City of Portland, Maine - Building or Use Permit

Permit No: 10-1327	Date Applied For: 10/22/2010	CBL: 040 D001001	
Location of Construction: 20 DANFORTH ST	Owner Name: BROWN J B & SONS	Owner Address: PO BOX 207	Phone:
Business Name: 	Contractor Name: Scarboro Signs	Contractor Address: 680 US Rt. 1 Scarborough	Phone: (207) 883-6796
Lessee/Buyer's Name: 	Phone: 	Permit Type: Signs - Permanent

Proposed Use: Commercial -Mixed Use - Hanging sign for "The Trust for Public Land"	Proposed Project Description: Hanging sign for "The Trust for Public Land" - 24" x 41"
---	---

Drawing file: 1. Original Plans / Heighth from Grade.pdf

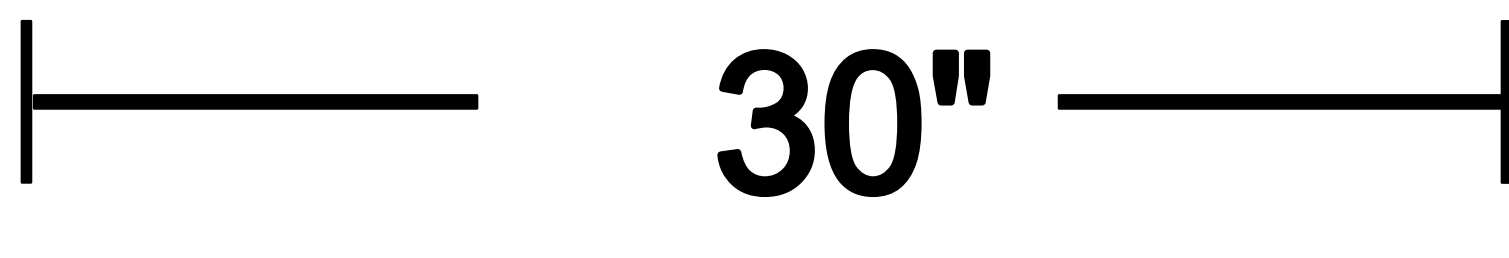
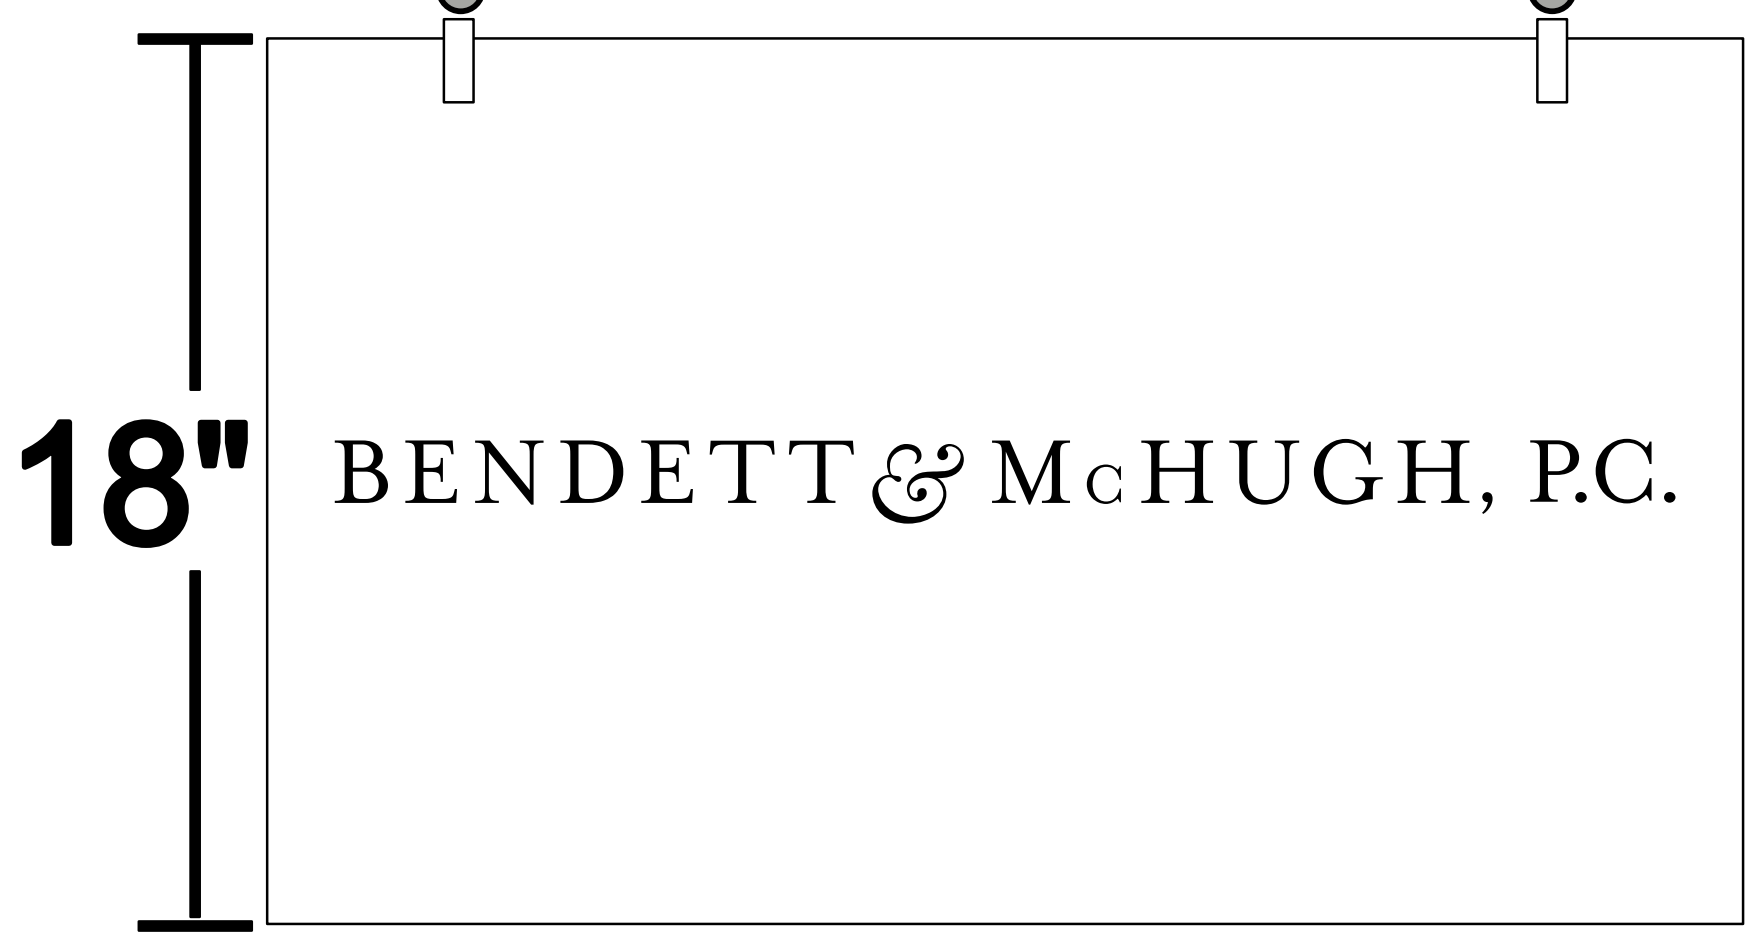
1) * Style of sign bracket to match existing sign brackets on building.

* Bracket to align vertically with other first floor sign brackets on building. (If the building owner chooses, the existing sign brackets may be raised slightly to accommodate the desired higher position of the applicant's bracket.) In no event shall there be a disparity in bracket heights

2) Encroachments into public ways must be a minimum of 8' above grade per section 3202 of IBC 2003.
